Rosefield Solar Farm

Schedule of Changes to the Draft DCO (Clean)

EN010158/APP/8.1.2
Revision 2
Deadline 1
March 2026
Rosefield Energyfarm Limited

Schedule of Changes to the Draft DCO

DRAWING TITLE:  
**STREETS, RIGHTS OF WAY AND ACCESS PLANS**  
 KEY PLAN

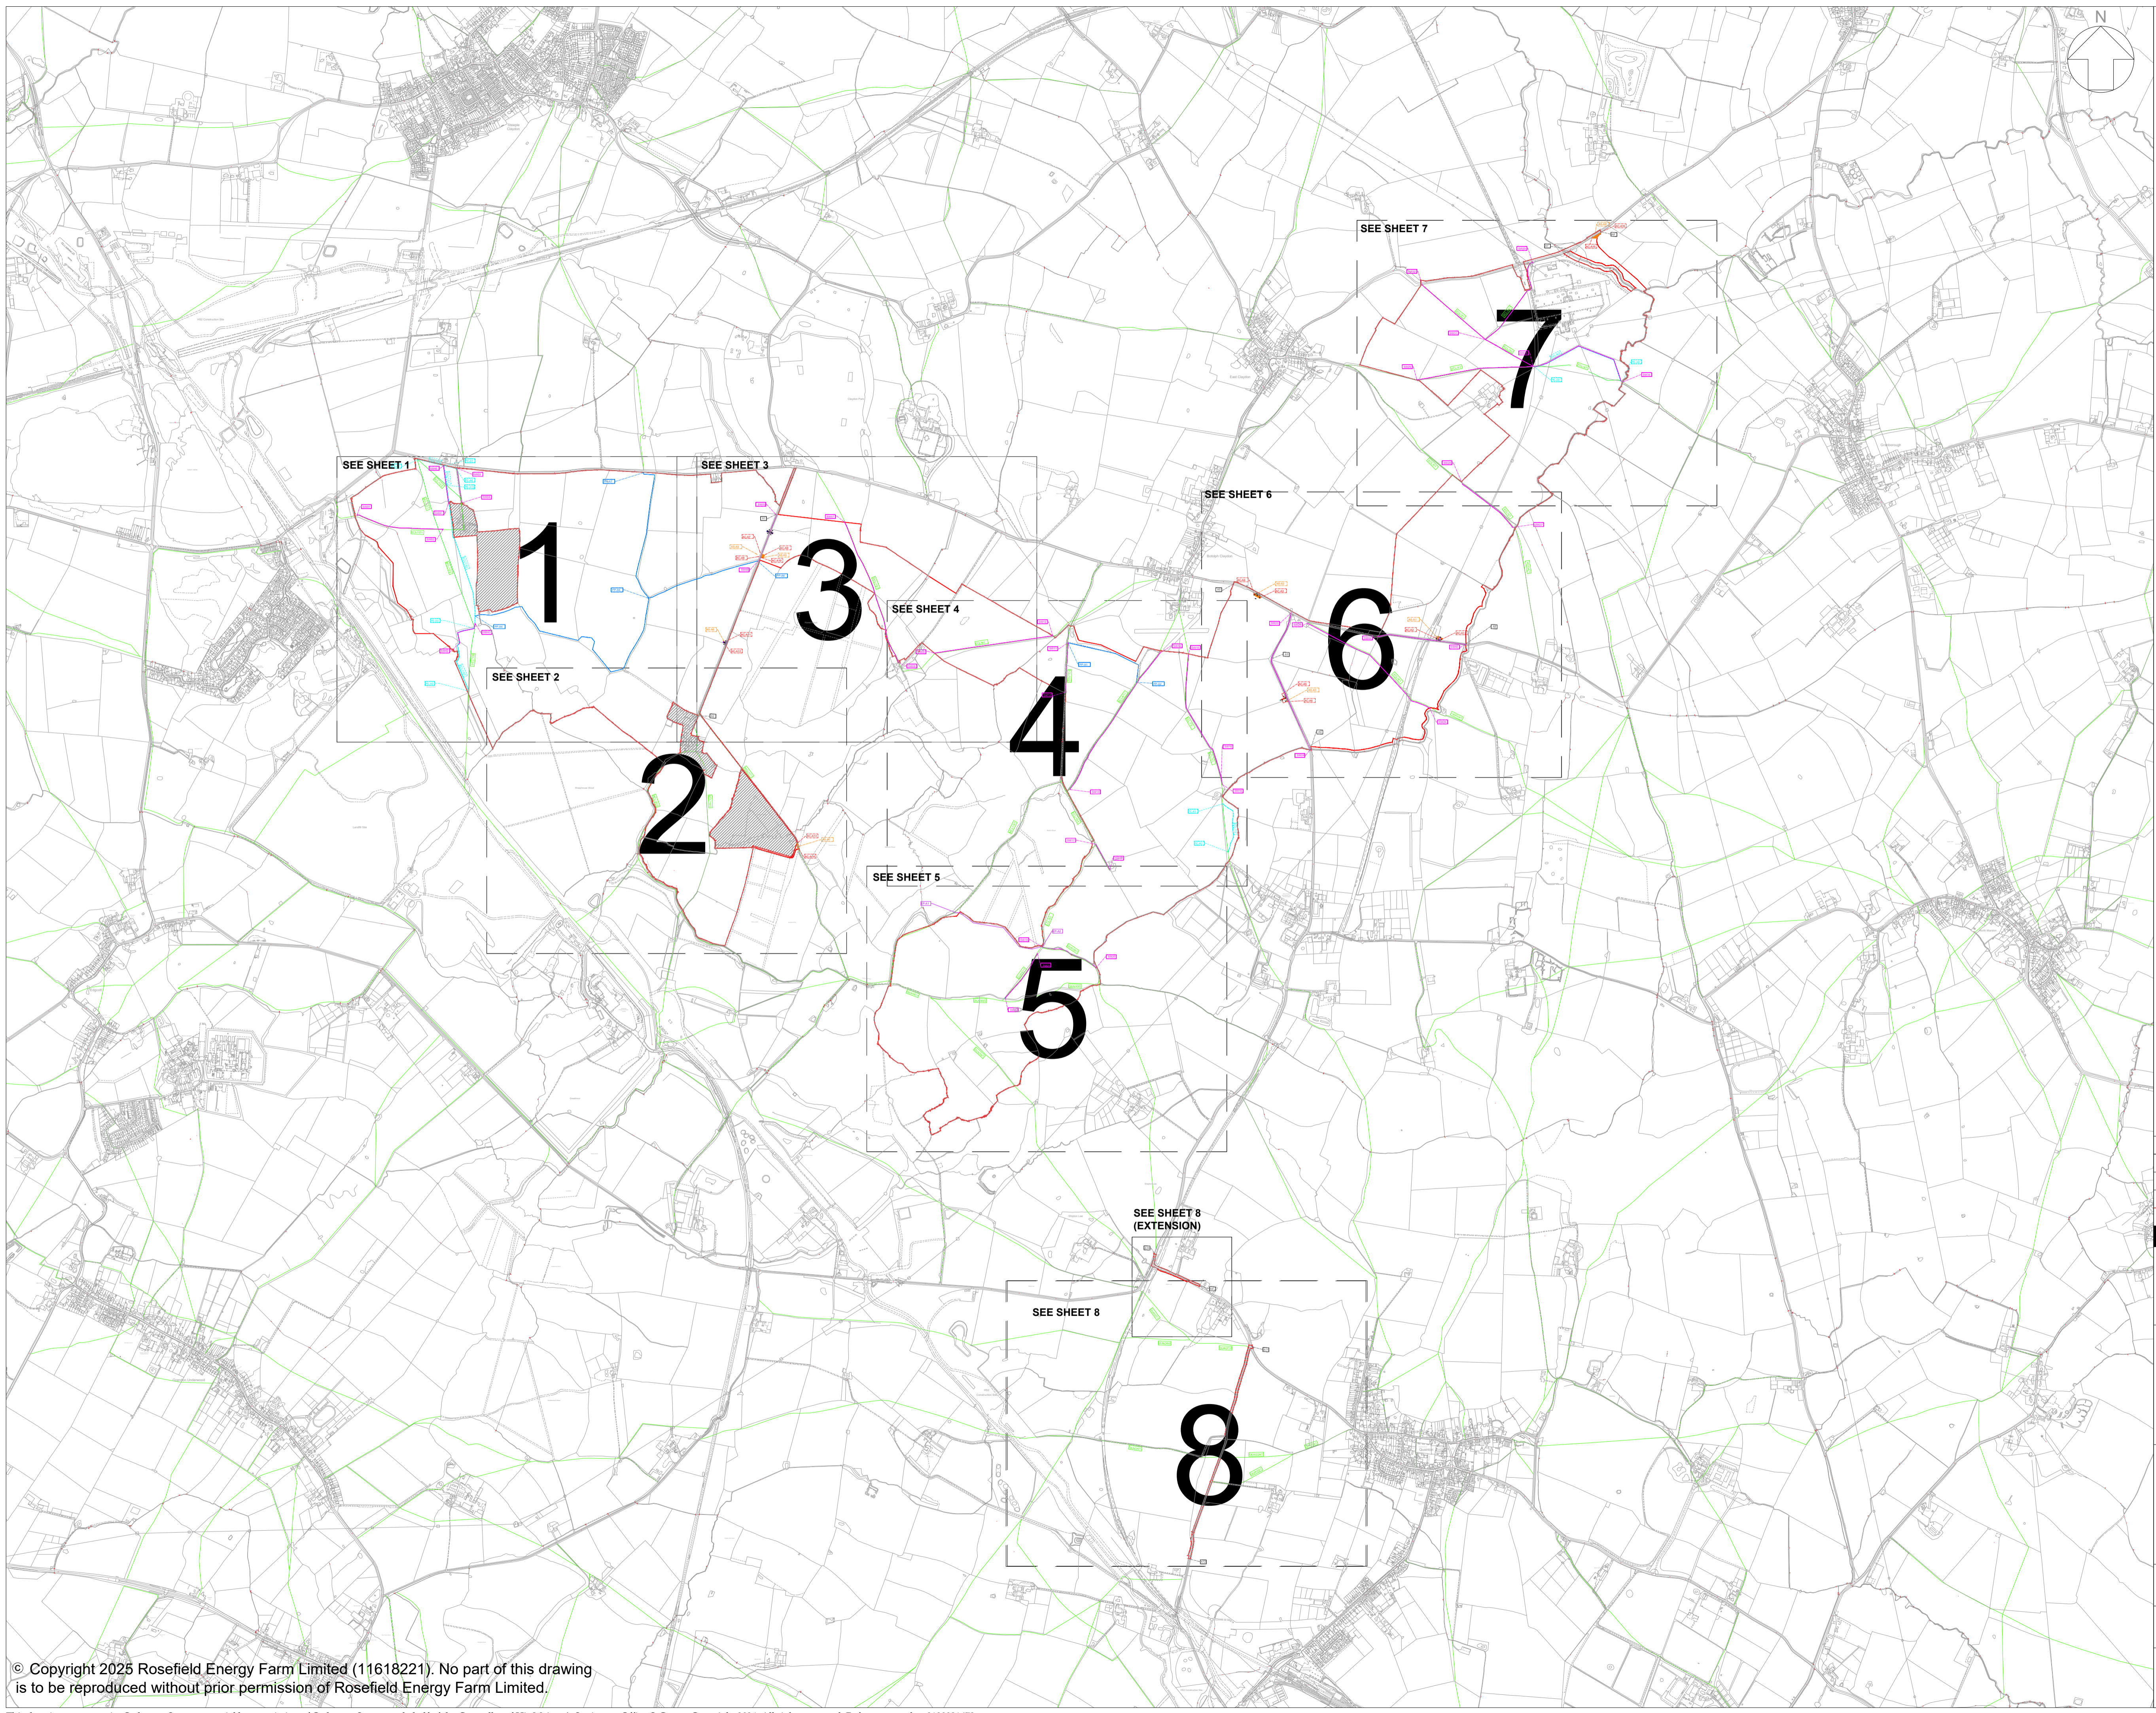
Reference	Change	Reason for Change	Deadline								
	<p>(2) The written details under sub-paragraph (1) must be substantially in accordance with the outline drainage strategy.</p> <p>(3) Any approved strategy must be implemented as approved and maintained throughout the construction and operation of the authorised development.</p>	relevant representation [RR-012], where each requested to be a consultee.									
Schedule 2, Requirement 14 (Operational noise)	14. – (1) No part of Work Nos. 1 to 5 may commence until an operational noise assessment containing details of how the design of that numbered work has incorporated mitigation to ensure the operational noise rating levels as set out in paragraph 13.9.19 of chapter 13 of the environmental statement are complied with for that part has been submitted to and approved by the relevant planning authority.	Addition of reference to more specific operational noise limits on the face of dDCO.	1								
Schedule 6, Part 1 (PRoW to be permanently stopped up and diverted)	<table border="1"> <thead> <tr> <th>(1) Area</th> <th>(2) Public right of way to be stopped up</th> <th>(3) Extent of stopping up</th> <th>(4) New public right of way to be substituted / provided</th> </tr> </thead> <tbody> <tr> <td>District of Buckinghamshire</td> <td>SCL/12/2</td> <td>For a distance of 320 190 metres between points PE-A7 PE-A10 and point SW04 as shown on sheet 1 of the streets, access and rights of way plans.</td> <td>New public footpath to be provided between points PE-A7, PE-A5 and its intersection with SCL/12/1 as shown by a cyan line on sheet 1 of the streets, rights</td> </tr> </tbody> </table>	(1) Area	(2) Public right of way to be stopped up	(3) Extent of stopping up	(4) New public right of way to be substituted / provided	District of Buckinghamshire	SCL/12/2	For a distance of 320 190 metres between points PE-A7 PE-A10 and point SW04 as shown on sheet 1 of the streets, access and rights of way plans.	New public footpath to be provided between points PE-A7, PE-A5 and its intersection with SCL/12/1 as shown by a cyan line on sheet 1 of the streets, rights	Reduction in extent of stopping up to SCL/12/2 to address Buckinghamshire Council’s relevant representation [RR-026] to avoid creation of a ‘dead-end’.	1
(1) Area	(2) Public right of way to be stopped up	(3) Extent of stopping up	(4) New public right of way to be substituted / provided								
District of Buckinghamshire	SCL/12/2	For a distance of 320 190 metres between points PE-A7 PE-A10 and point SW04 as shown on sheet 1 of the streets, access and rights of way plans.	New public footpath to be provided between points PE-A7, PE-A5 and its intersection with SCL/12/1 as shown by a cyan line on sheet 1 of the streets, rights
